Submission No.			149	
Organisation Name or Name of Submitter			John Conway and Orlaith McCarthy (15 Dartmouth Square West)	
Item No.	Section Ref.	Page No.	Observation Statement	TII Response
Observation on a Startegic Infrastructure Development				
1	Letter introduction	3	<p>Our names are John Conway and Orlaith McCarthy. We have been living at # 15 Dartmouth Square West for more than 40 years.....</p> <p>It is important to state at the outset that we are very much in favour of the Metrolink project to connect Dublin’s city centre to our national airport and the broader objective of providing a modern and efficient public transport infrastructure for the people of Dublin. That is why we have a number of concerns that the current plan is not optimal and is wasteful of public money.</p> <p>We want to set out a number of observations for the Board regarding the proposal to locate the city centre Terminus station at Charlemont-Dartmouth. Our family home is in the midst of the community where the Terminus station is proposed to be located.</p>	<p>Thank you for taking the time to make a submission and your overall endorsement of the MetroLink Project. We have reviewed your submission and

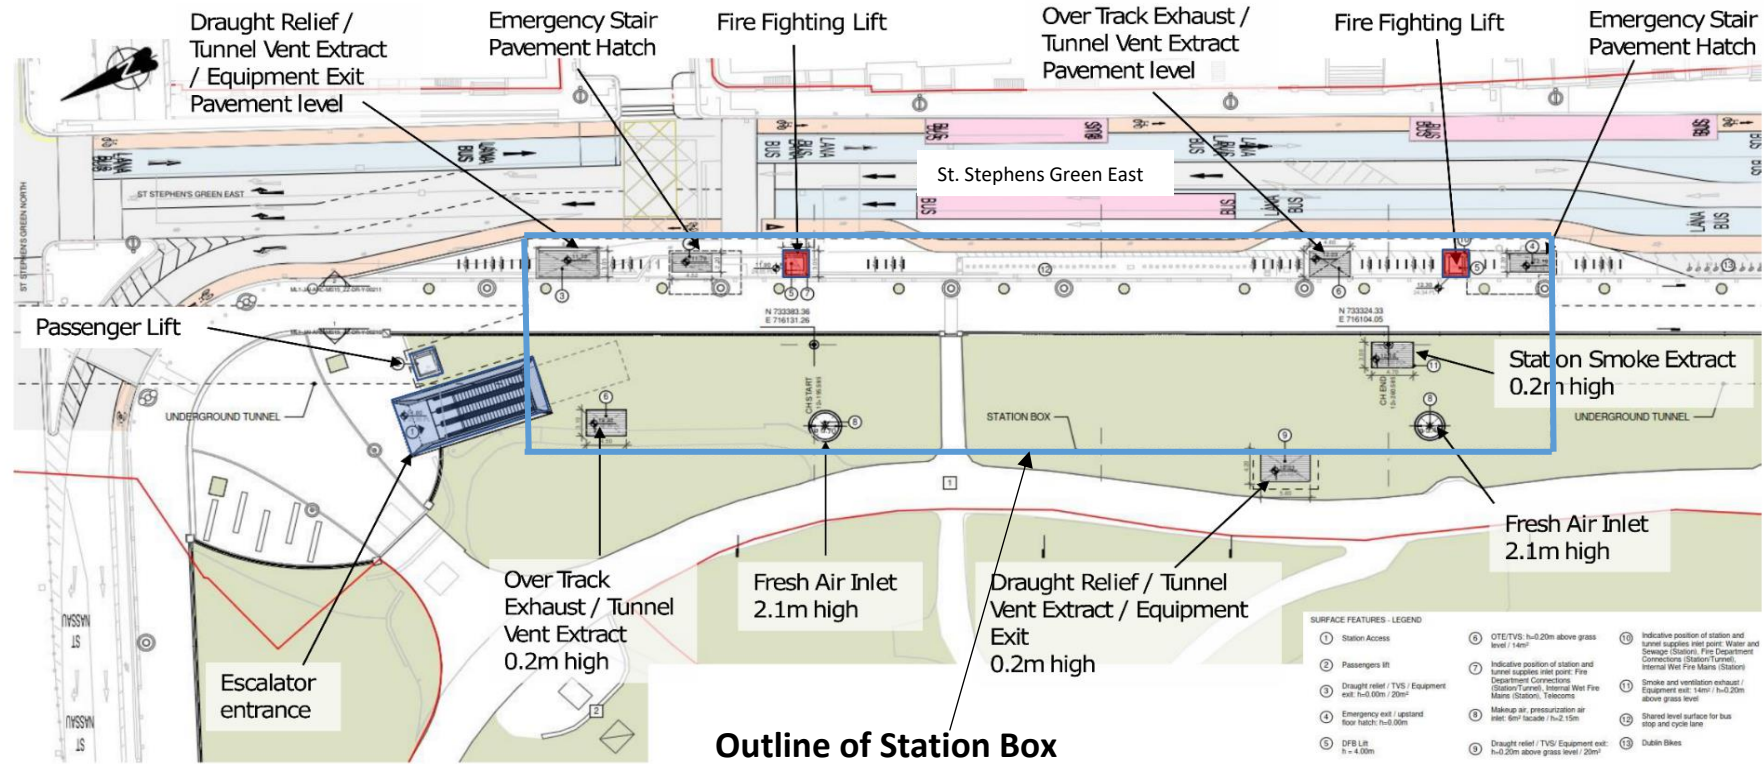
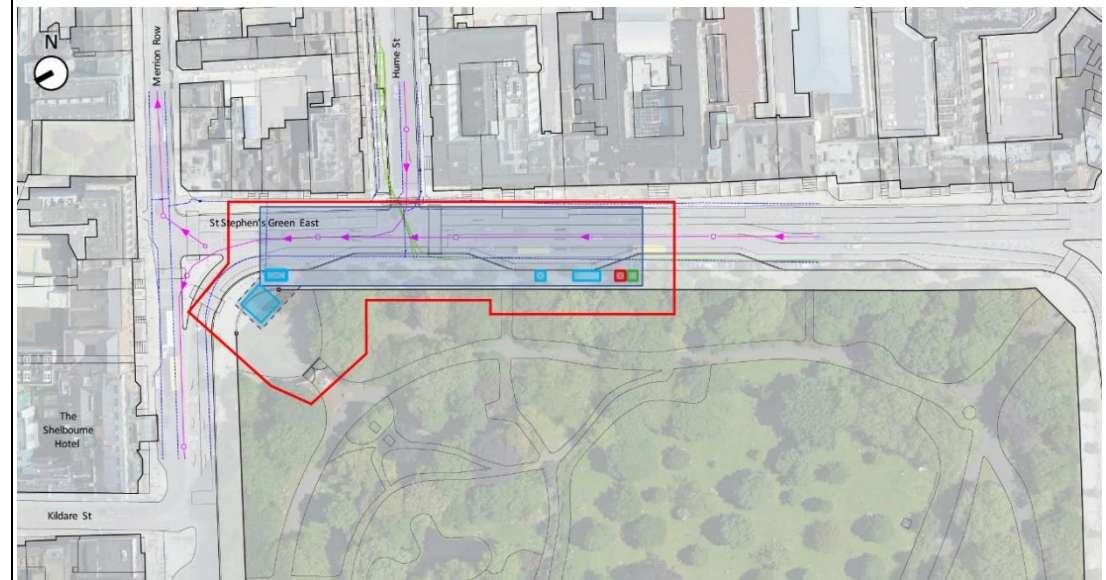
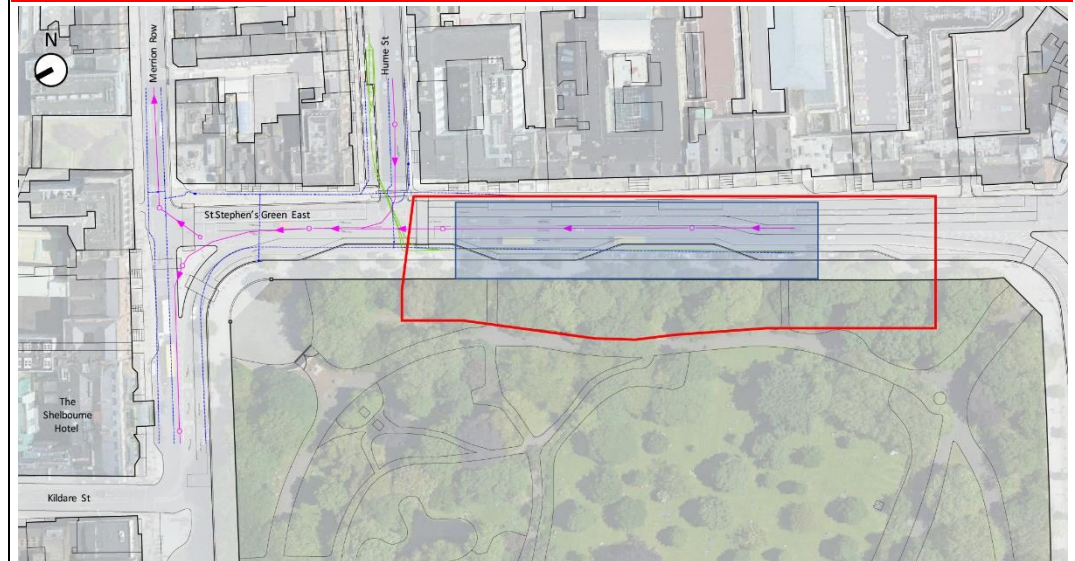
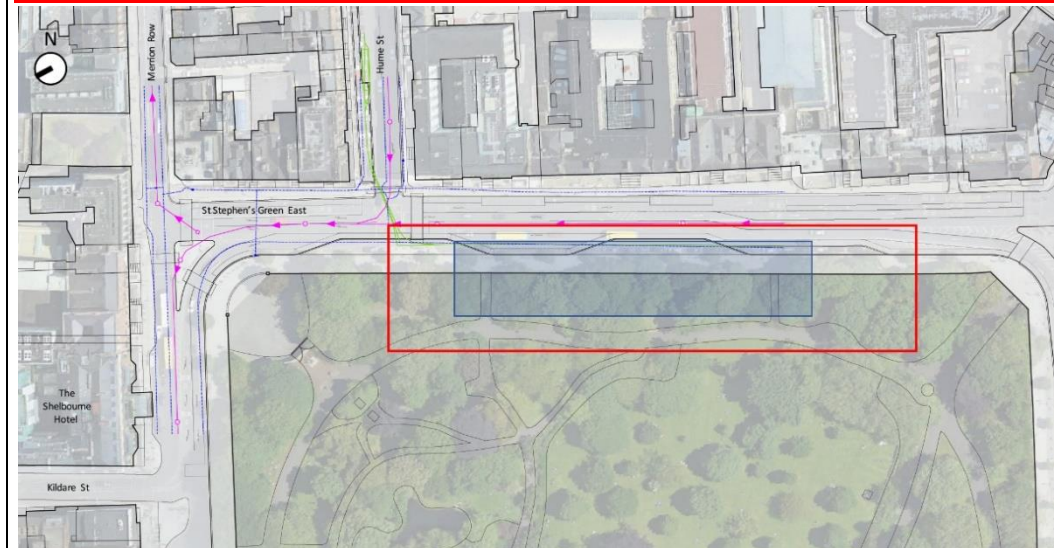
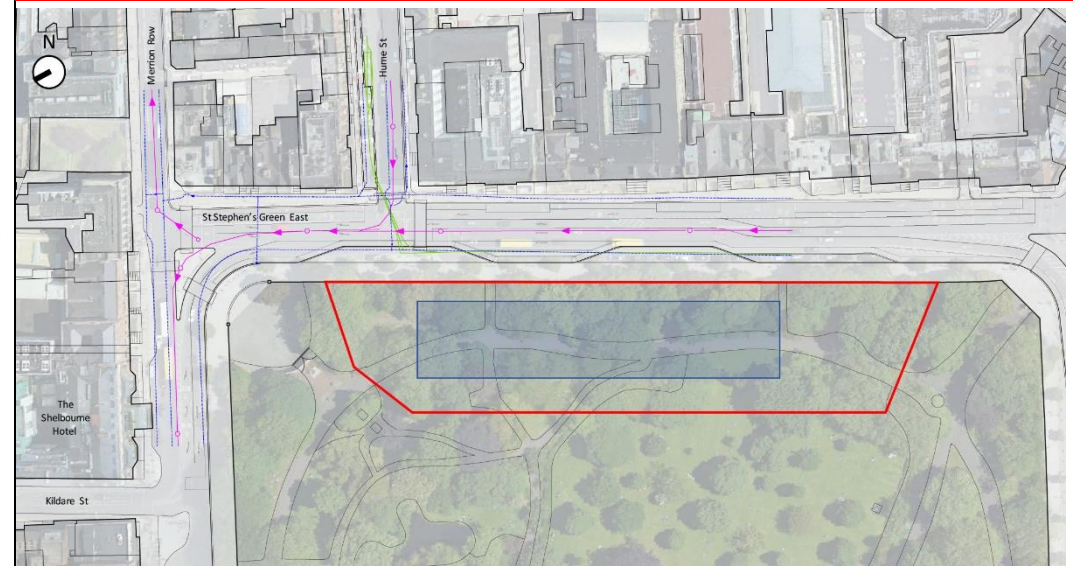
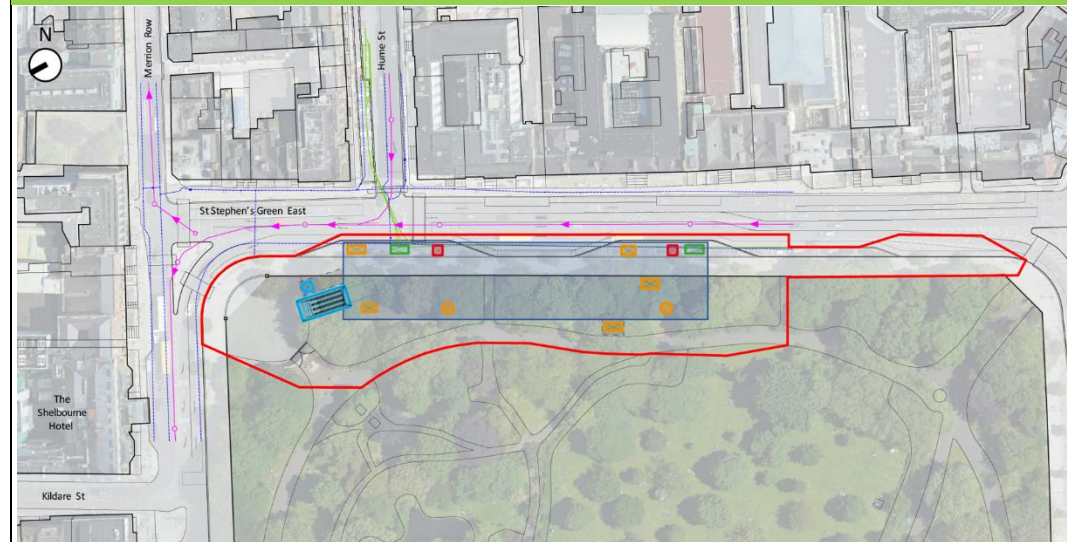
3	(a) Strategy & Policy Issues	4	<p>1. (continued)</p> <p>St. Stephens Green is the most appropriate location for the Terminus as it provides for interchange with bus, Luas and future DART underground. The project incorrectly dismisses St. Stephens Green West as an appropriate terminal station. It only considers St. Stephens Green East and Charlemont. Furthermore, no study has been completed by NTA/TII as part of the entire Metrolink project on the optimal location for a city centre terminus.</p>	<p>TII do not agree that St Stephen's Green is the most appropriate interchange location for the reasons set out by response (2) above.</p> <p>It is not correct to say that the Project "only considers St. Stephens Green East and Charlemont." A number of route options were considered in the process of identifying the Emerging Preferred Route (EPR). These route options included potential station locations on St. Stephen's Green West. However these options were ruled out as it was not possible to design an alignment that would also provide a MetroLink interchange with DART at Tara Street Station.</p> <p>A station on St Stephen's Green West is not preferred for several reasons:</p> <p>If a station was placed on St Stephen's Green West, the alignment between the proposed Tara Station and a station on St Stephen's Green West would result in an undesirable horizontal reverse curve and an alignment greater than a 1000m long that would necessitate an intermediate intervention shaft located somewhere between these stations to comply with the MetroLink Fire Strategy. Additional construction would be required to provide such a facility, similar in size to the proposed Albert College Park Intervention shaft. This could feasibly be situated in the Trinity College Dublin sports grounds.</p>

<p>TII note that it is Government policy to provide a station and interchange with the Luas Green Line at Charlemont, as set out by the GDA Transport Strategy 2022 – 2042. Should a station be placed on St Stephen's Green West, the alignment between a station located here and the proposed Charlemont Station would also result in an undesirable horizontal reverse curve and an alignment that is greater than 1000m long, and would thus again require an intervention shaft similar to the proposed Albert College Park Intervention shaft to be provided. This would be expected to result in significant demolition and redevelopment in an existing built-up area.In both cases, compared to the proposed alignment that runs much more directly between Tara, St Stephen's Green and Charlemont, the additional length of tunnel and the addition of two intervention shafts generated by locating a station on St Stephen's Green West is uneconomic in comparison.</p> <p>As a potential station location, St Stephen's Green West itself is a very constrained location due to the presence of buildings, Luas and St Stephen's Green Park. Maintaining the Luas operational during station construction would be complex and challenging with significant disruption expected, whilst the impacts on St Stephen's Green Park would be greater for a station in this location compared to the proposed location on St Stephen's Green East. This would be the result of; the likely need to place more of the station in the Park compared to the proposed station on St Stephen's Green East; it would impact an area of the Park that has greater amenity value than St Stephen's Green East due to the nearby Park entrance adjacent to the southern end of Grafton Street, and there would be a risk of impacting the existing Park lake.</p>
